Planning Application Ref: BE/63/17/OUT (2)

Location: The Cottage, Shripney Road, Bognor Regis

Description of works: Erection of 21 new houses and flats with access and parking and landscaping.

Consultant Arboriculturist

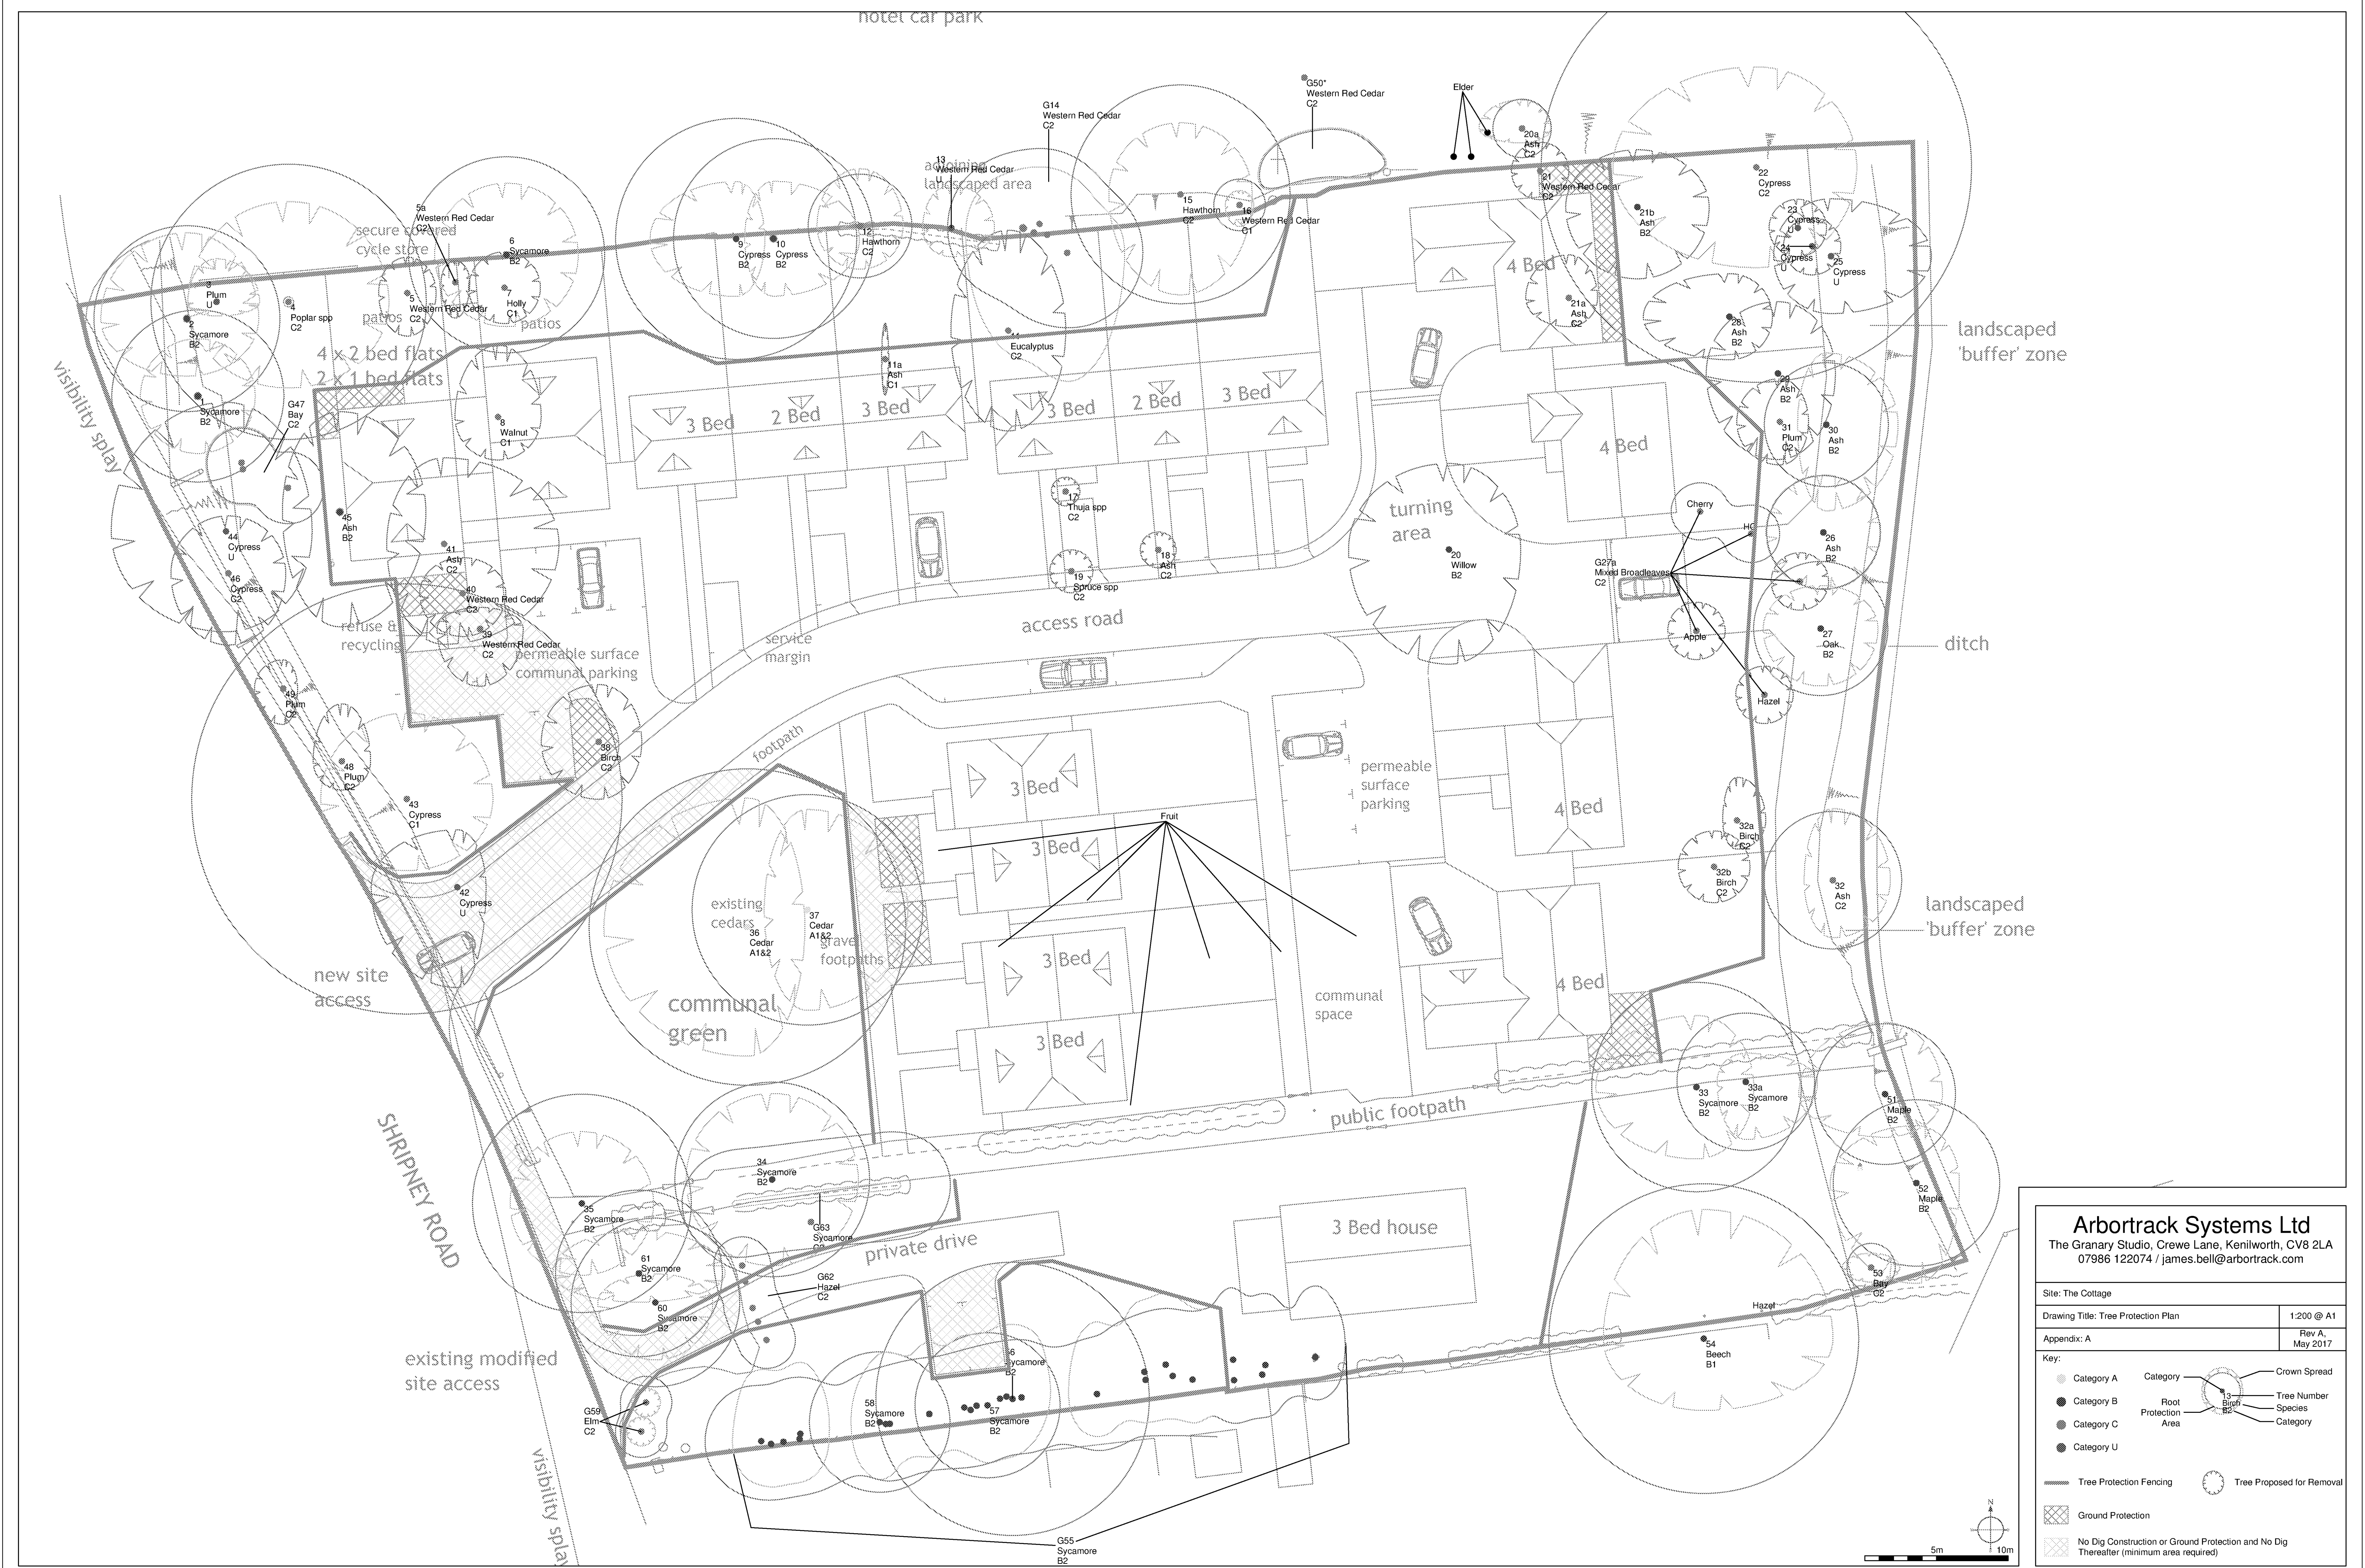
- The primary trees of significance on the frontage of the main house plot are **T45 Ash and T36/37 Cedars** both of which will be compromised by the layout requiring mitigation measure to make the layout fit – better I feel to adjust the layout to fully accommodate them even if this means removing some more trees of lesser merit. My suggestion would be to remove **Macrocarpa T43** (a poor quality tree with a short life expectancy) and this would allow the road to be moved northwards and outside that RPA for T36/37.

- Further to this I would like to see the four 3 Bed Plots to the east of T36/37 moved back and fully outside of T36/37 RPA's so that footpaths are outside them.

- As far as **45 Ash** is concerned I would wish to see the Flats moved 1m further east so that there is no overlap of the RPA for this tree.
- With regards to the Plot to the south side of the public footpath I would like to see the access drive adjusted to be fully outside the RPA for **Sycamore T34** towards the lesser value trees to the south.
